REQUEST	Current Zoning: O-2, office district Proposed Zoning: MUDD-O, mixed use development district, optional
LOCATION	Approximately 1.3 acres located on the south side of Kenilworth Avenue between E. Morehead Street and Harding Place
CENTER, CORRIDOR OR WEDGE	Wedge
SUMMARY OF PETITION	The petition proposes a 155,000 square foot mixed-use building and associated parking deck. The optional request will allow additional building height and an alternate location for water quality features.
STAFF RECOMMENDATION	The proposed land use is consistent with the Central District Plan. The optional request to increase the building height to 140-feet is within keeping of other buildings in the vicinity such as the hospital and the Metropolitan which are both 160-feet in height. The optional request to allow water quality features to be located within the setback under the sidewalk is acceptable. Staff is recommending APPROVAL of this petition upon resolution of the outstanding site plan issues.

Property Owner	GMA Industrial Corporation / Prime Solutions, LLC
Petitioner	Planet 5, LLC
Agent/Representative	Jeff Brown and Keith MacVean
Community Meeting	Meeting required and held. Report online.

1301 E. MOREHEAD ST.
TECHNICAL DATA SHEET

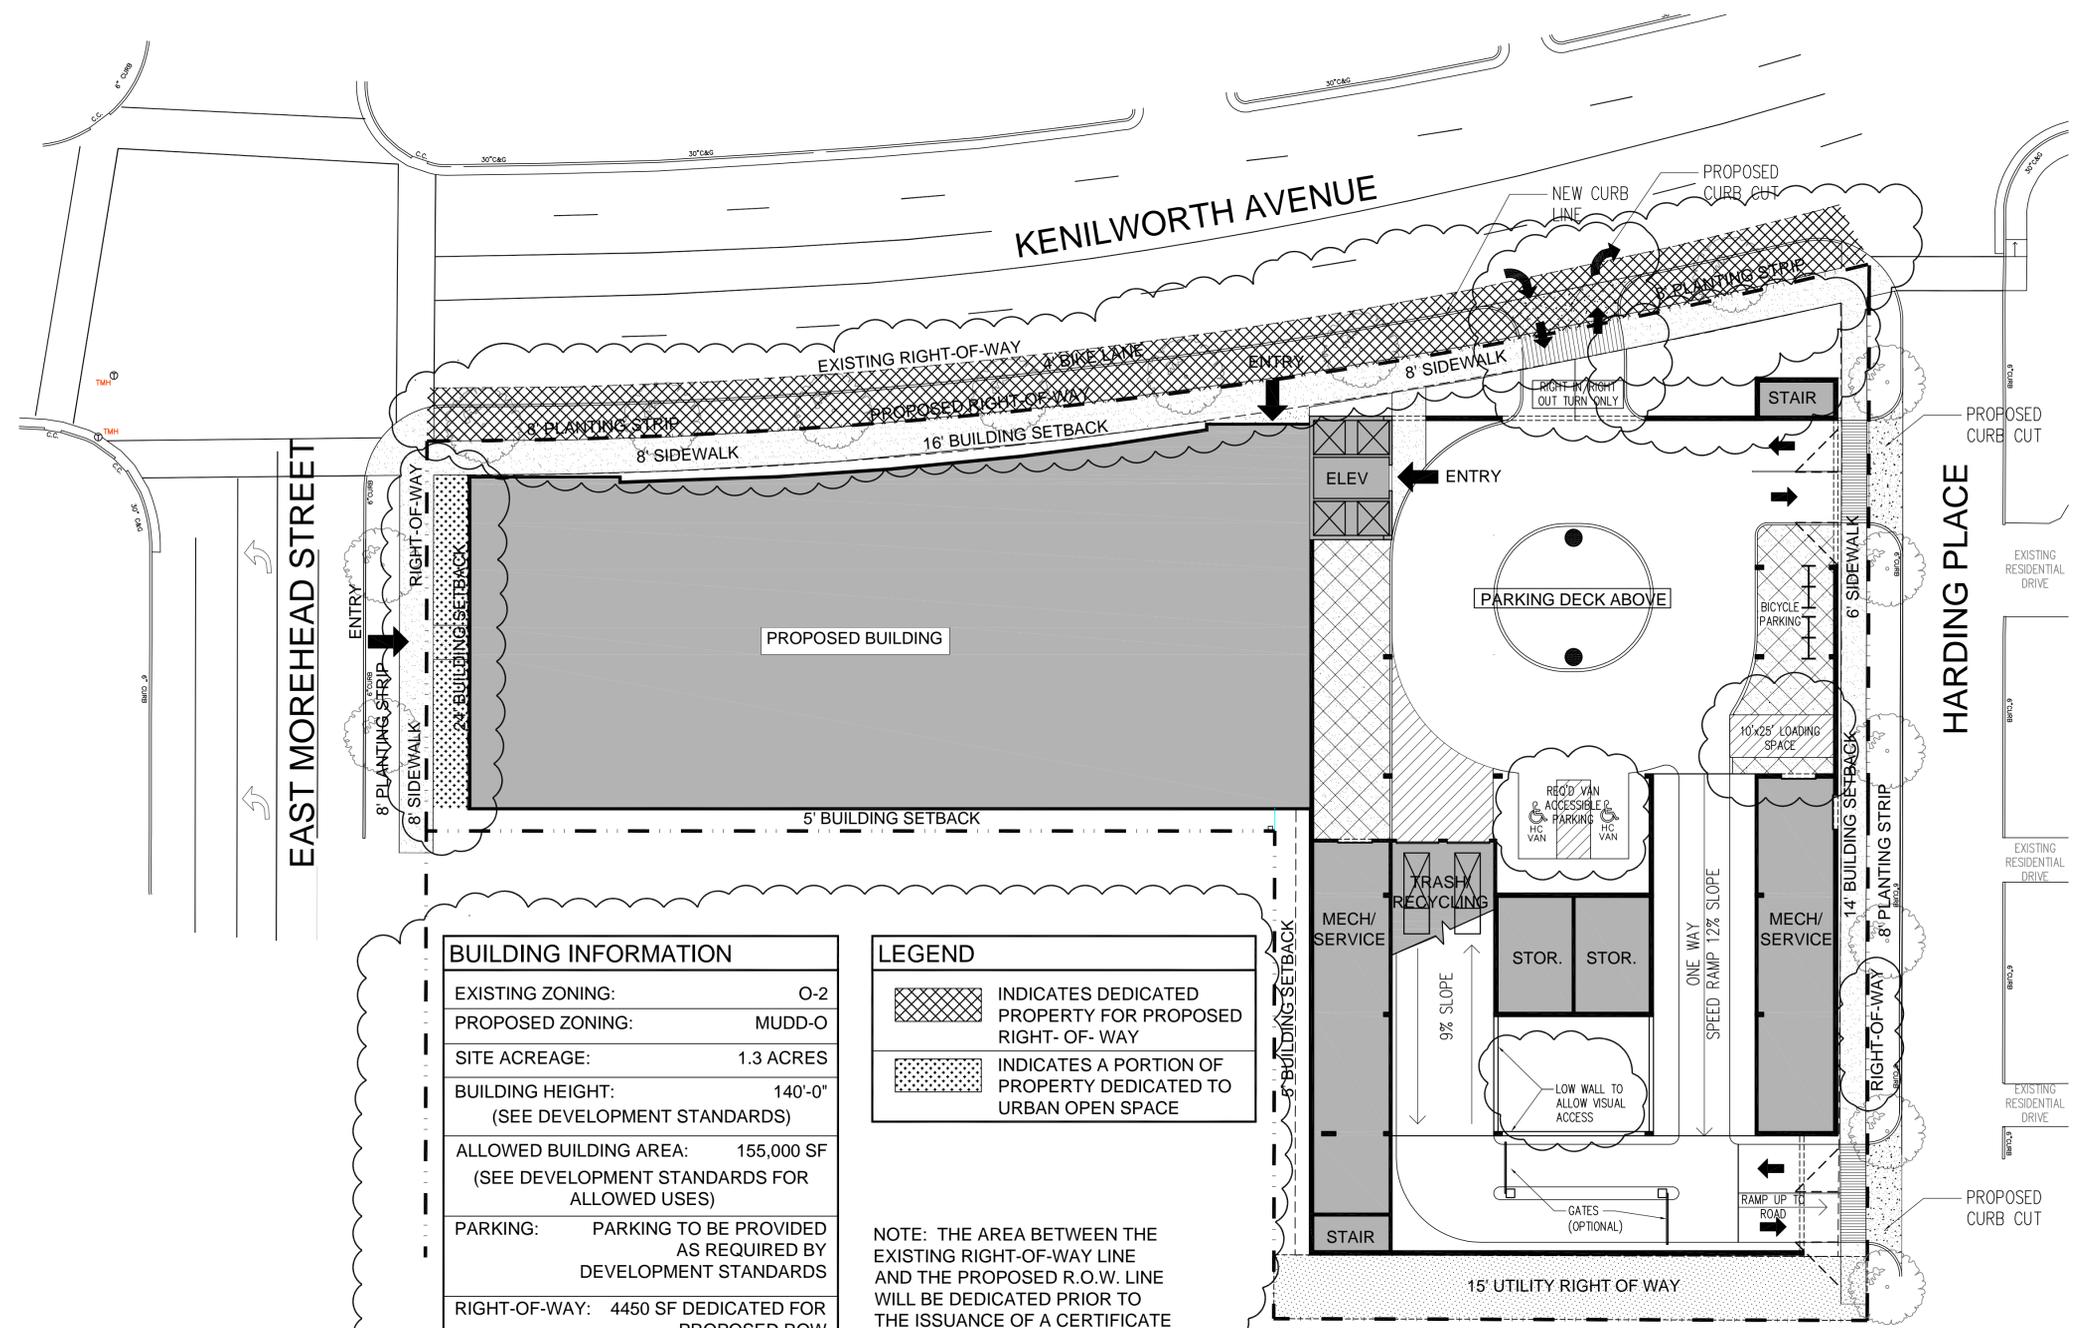
1. A conversion rate for the office use to residential use should be provided.
2. The right-of-way should be dedicated prior to the issuance of building permits not prior to the issuance of certificates of occupancy.
3. Additional architectural features should be provided along the southern walls adjacent to office property.
4. The notes should indicate that childcare facilities will comply with Section 12.502.
5. All street right-of-way should be dimensioned on the site plan.
